From: Andrew Wood
Sent: 19 August 2019 10:43
To: Planning.Responses
Cc: Lynnyrd Wolfe
Subject: FW: Shafiques of Angmering A/63/19/PL
Attachments: 867-03B Shafiques Angmering Proposed Layouts A3.pdf

Subject: RE: Shafiques of Angmering A/63/19/PL

PROJECT
SHAFQUES, THE SQUARE
ARUNDEL ROAD
ANGMERING
WEST SUSSEX
DRAWING TITLE
PROPOSED FLOOR PLAN, ROOF PLAN &
ELEVATIONS

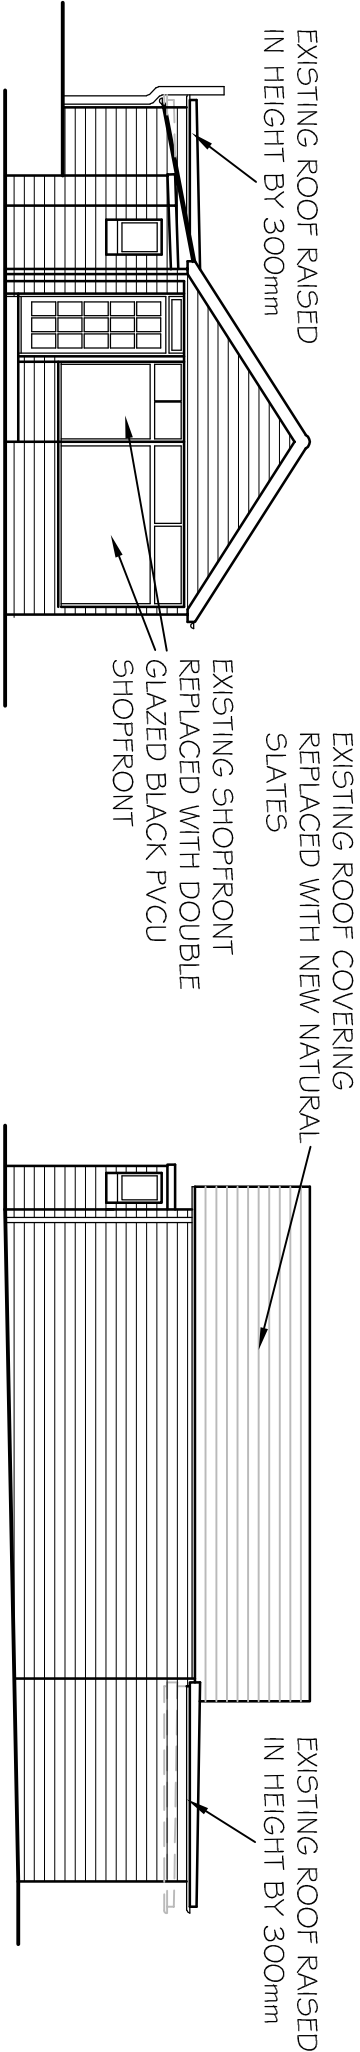
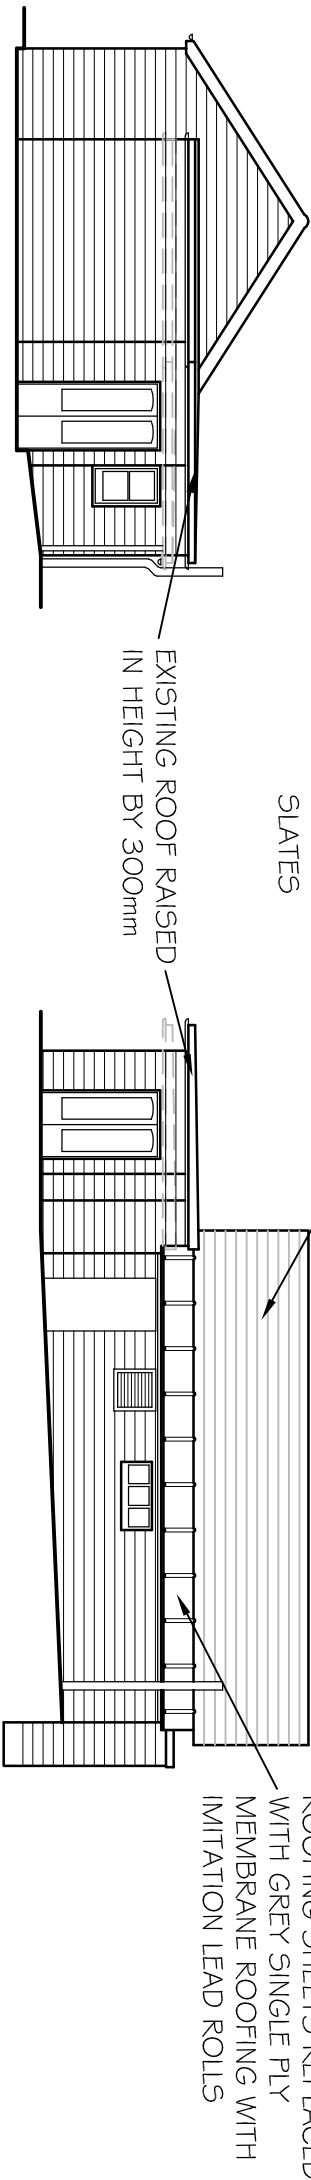
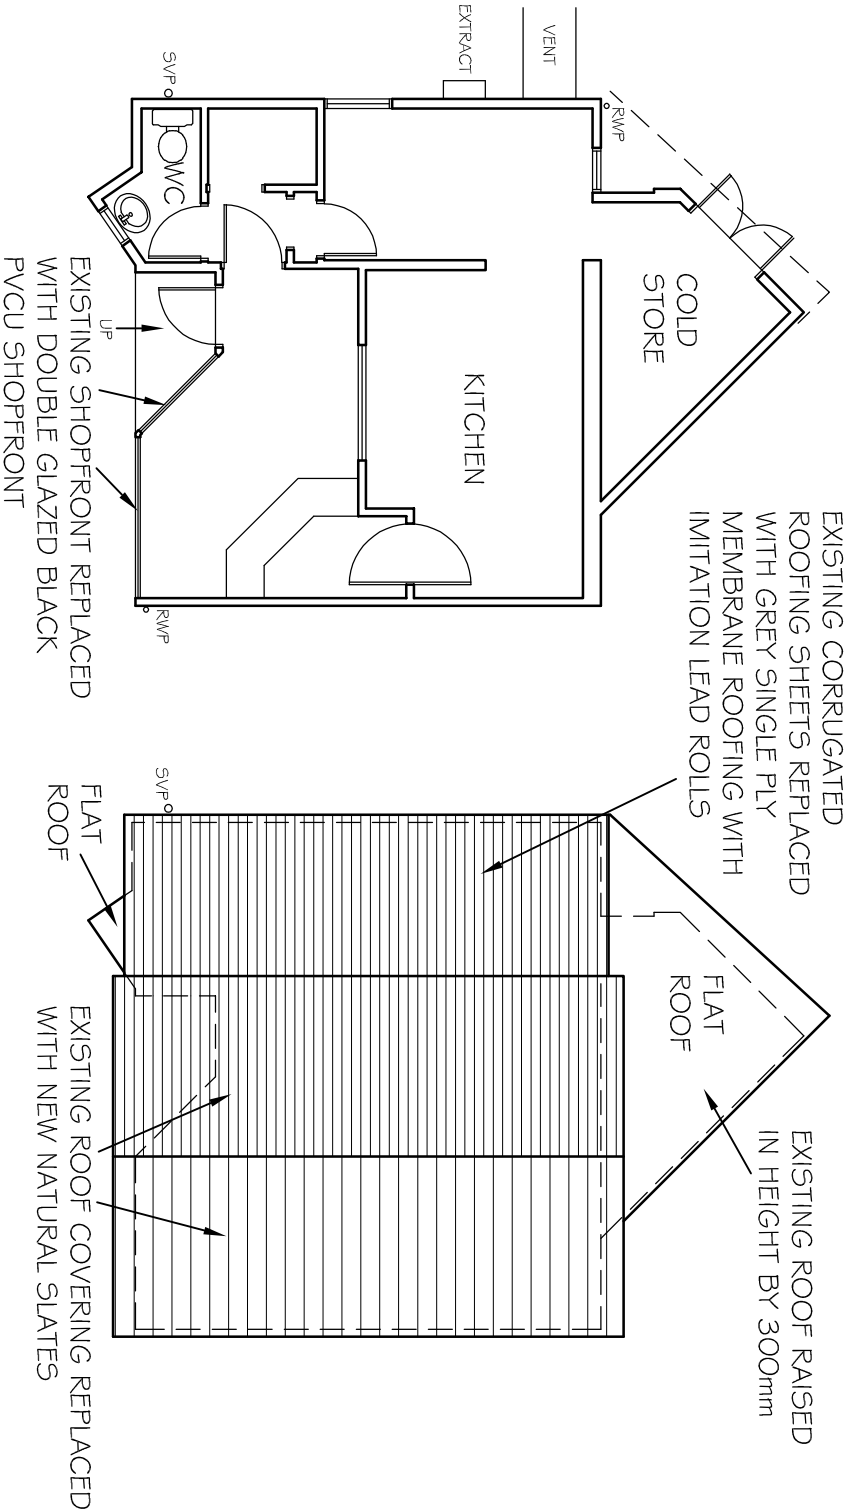
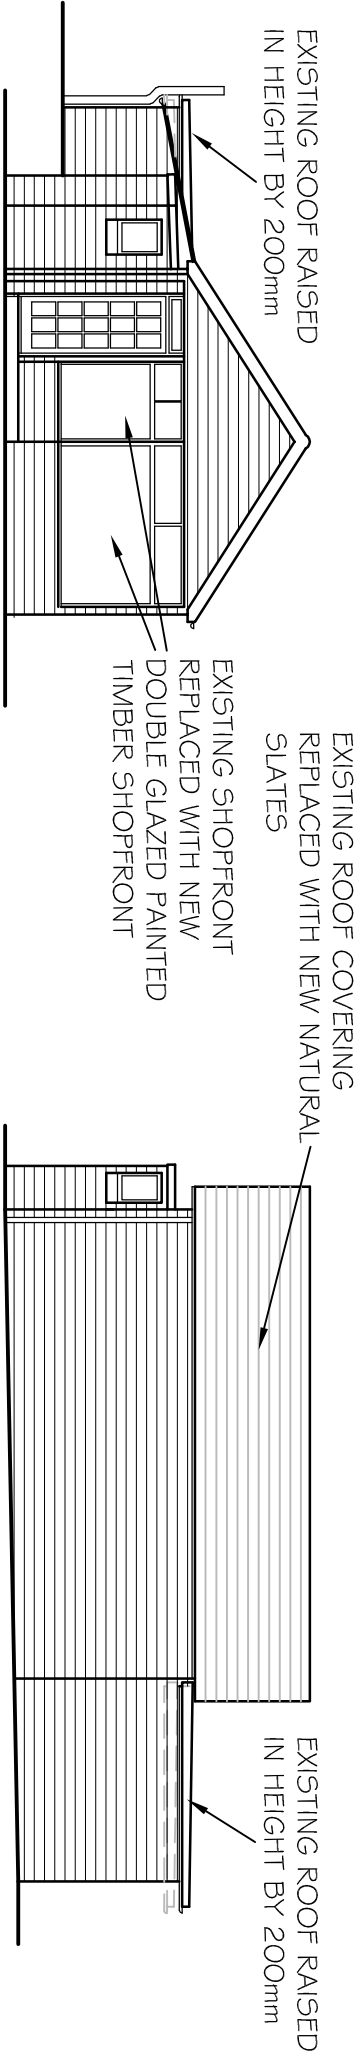
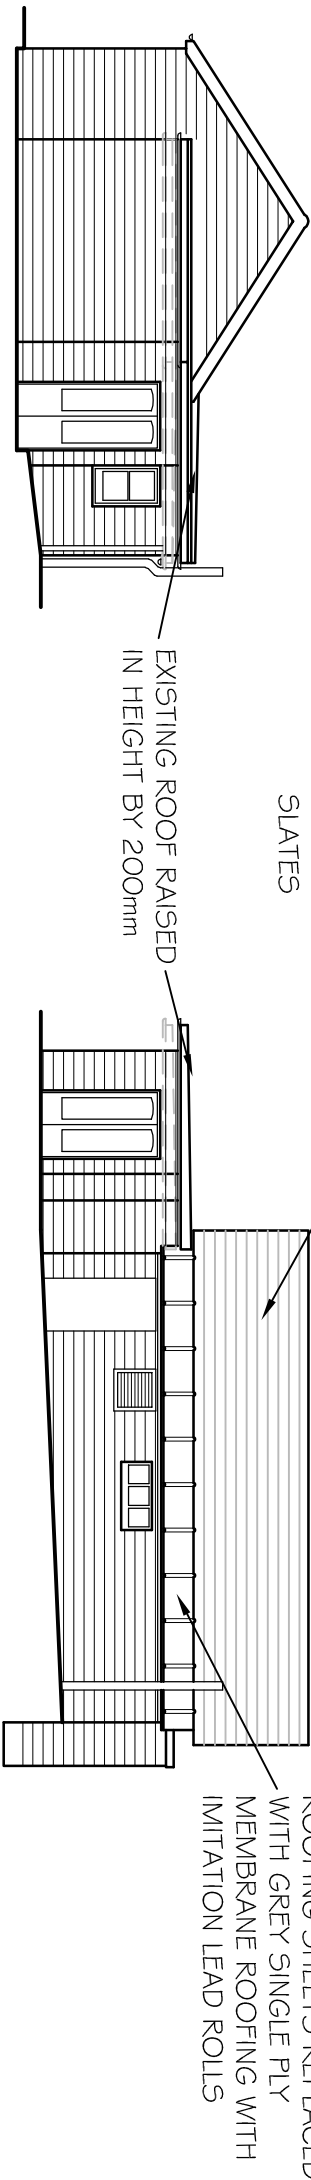
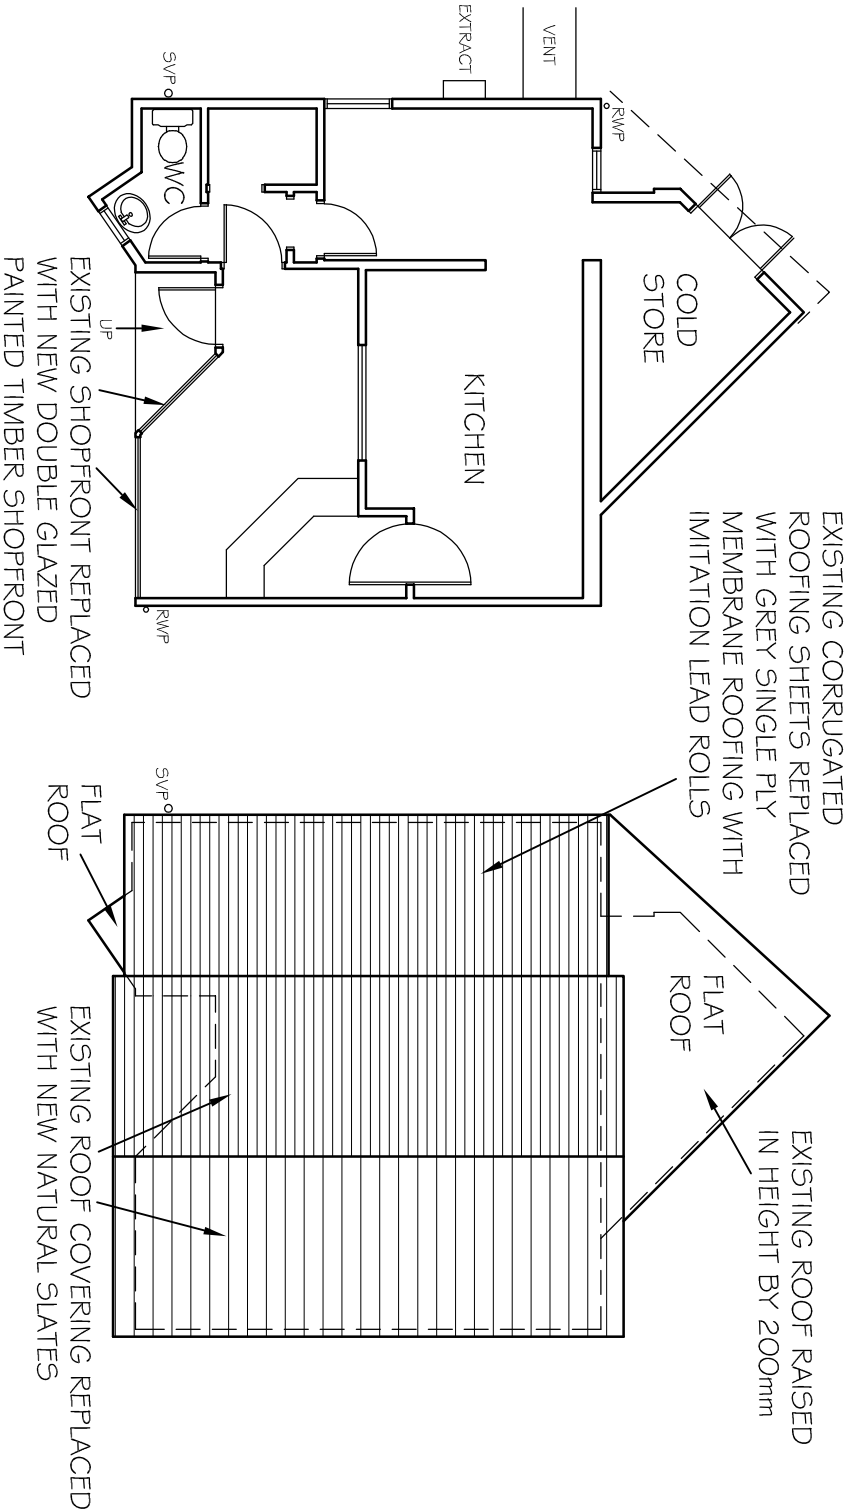
Please find attached slightly amended proposals which show the following revisions:

- Increase in rear roof height changed from 300mm to 200mm.
- Replacement shopfront changed to double glazed painted timber unit.

Could you just confirm that the proposed development would not block any additional width of the rear kitchen window of Blaber cottage ?.

We can confirm that the adjacent property to the East, Blaber Cottage, does indeed have a side facing window directly on the boundary of the site. However, this is a secondary window for the room that it serves, with the primary window being south facing. The window is at high level compared to the internal floor level of the room, which is significantly below the ground level to the rear of Shafiques. The proposals would not result in any additional width of the existing window being blocked. The existing flat roofed area to the rear of Shafiques is already at a height which is above the head height of the window, and the proposed increase in roof height of 200mm is not likely to make a significant difference to the amount of natural light that is experienced within the relevant room in Blaber Cottage. We would remind you that the increase in the roof height to the area to the rear of Shafiques is required in order to sensibly accommodate large refrigeration equipment which is required for the ongoing commercial operation of the premises. The issues associated with the current low ceiling / roof height can be clearly evidenced on site.
